## Application for Removal or Variation of a Condition following Grant of Planning Permission or Listed Building Consent

Change of use of part ground and first floor from community (Class F1) to office (Class E) use with associated external alterations, replacement plant and cycle parking.

21/00754/RE4

Amendments to GF entrances on No and E sides of building and external landscaping - submission of revised drawings

Drawing Title
Proposed Elevations

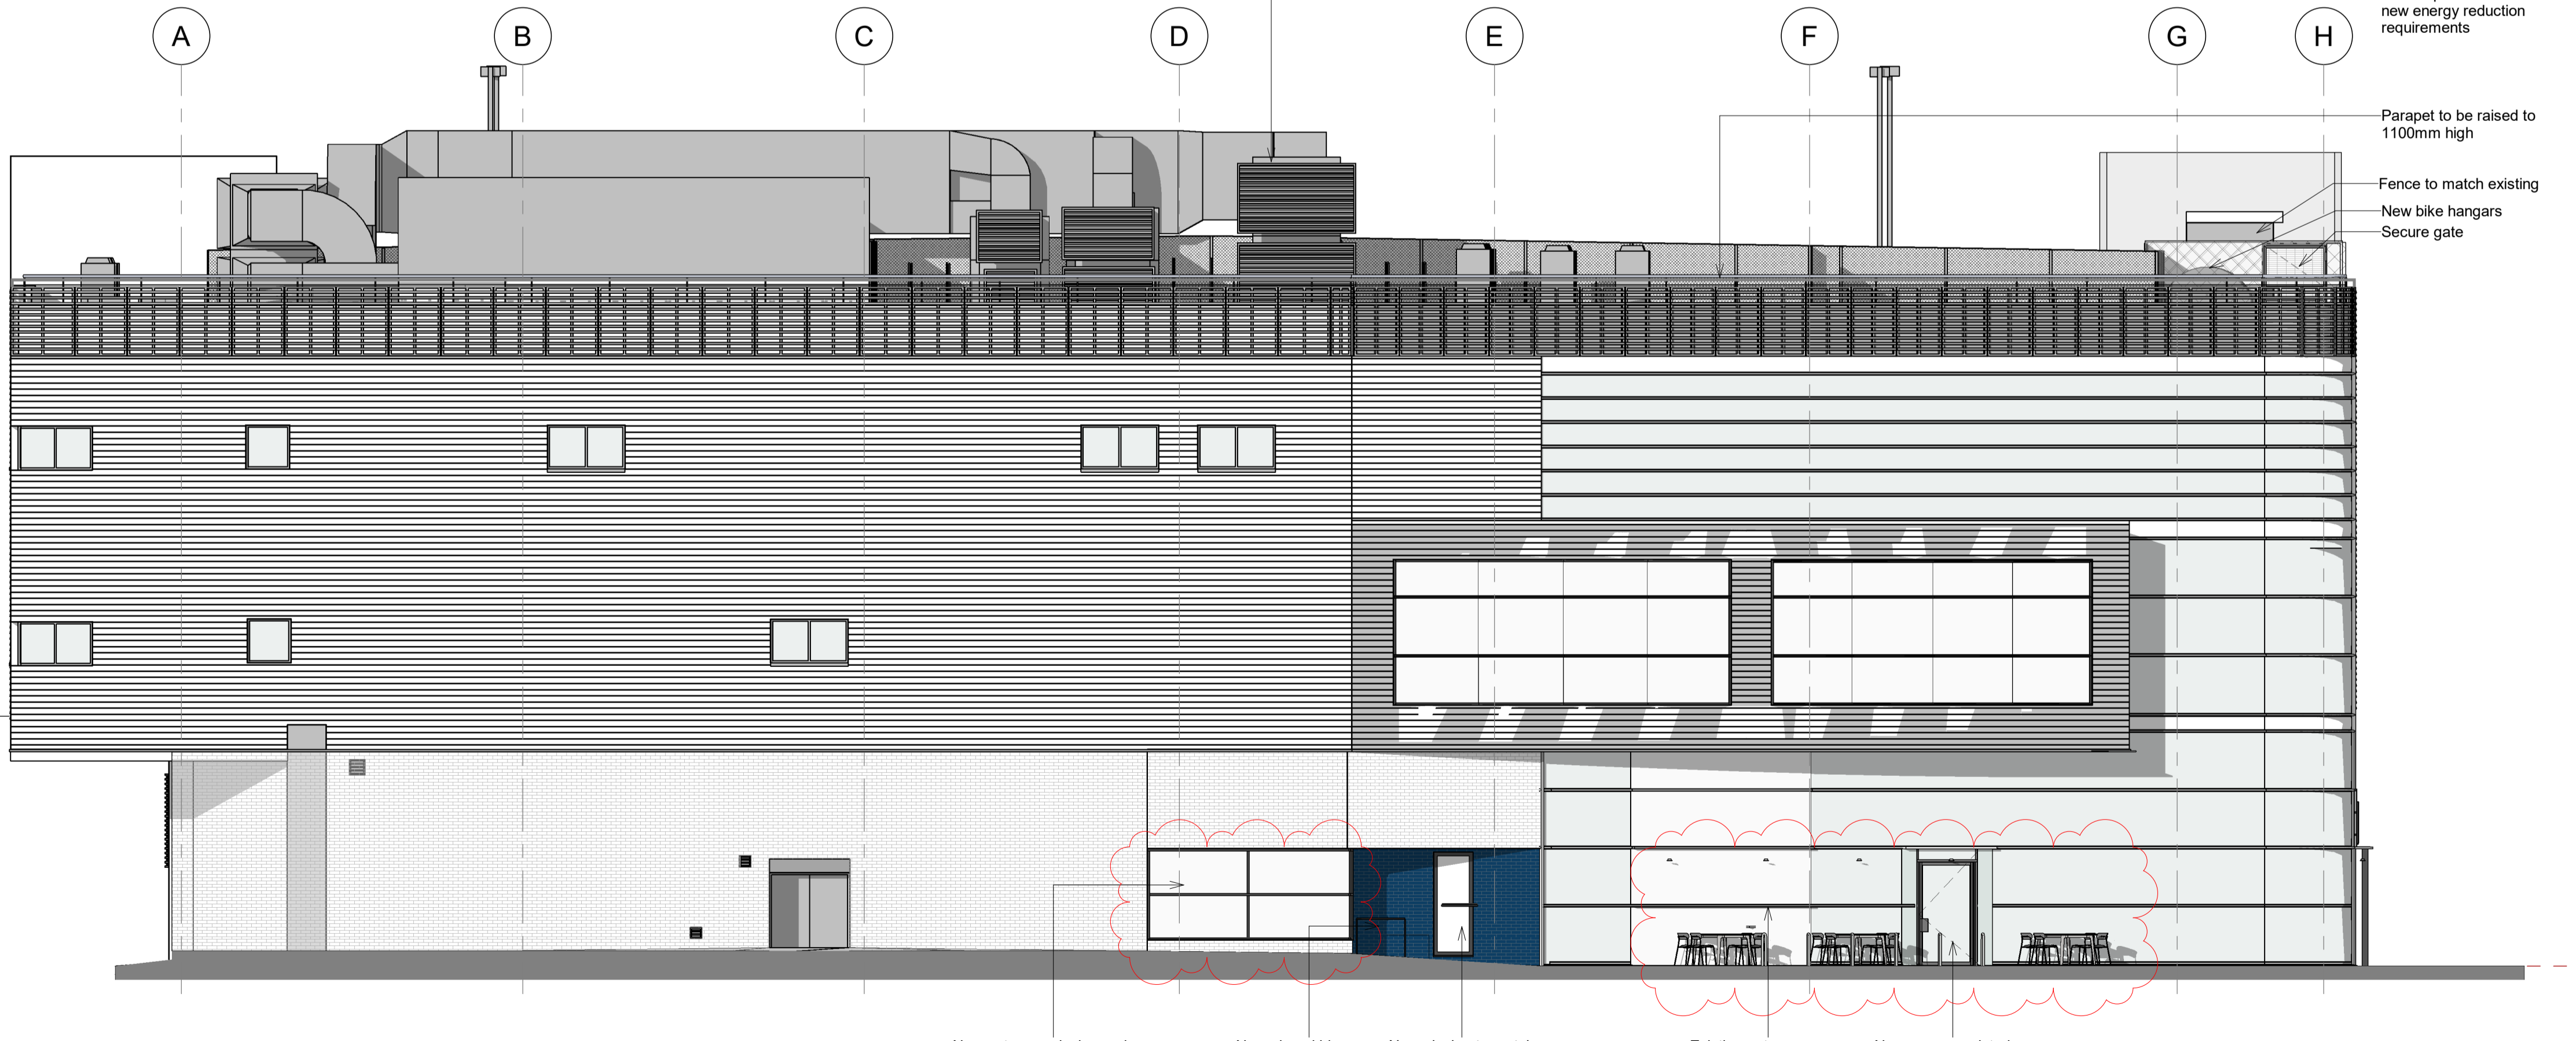
Elevation approved A11914D0202 rev P5 - replace with rev P6

Drawing Title  
**Proposed Ground Floor Plan**

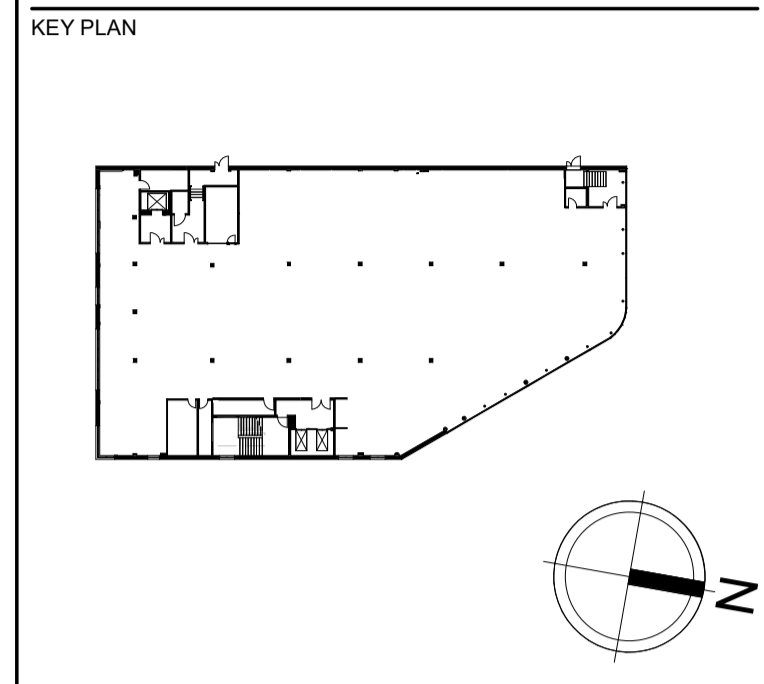
GF plan approved A11914D0100 rev P4 - replace with rev P6
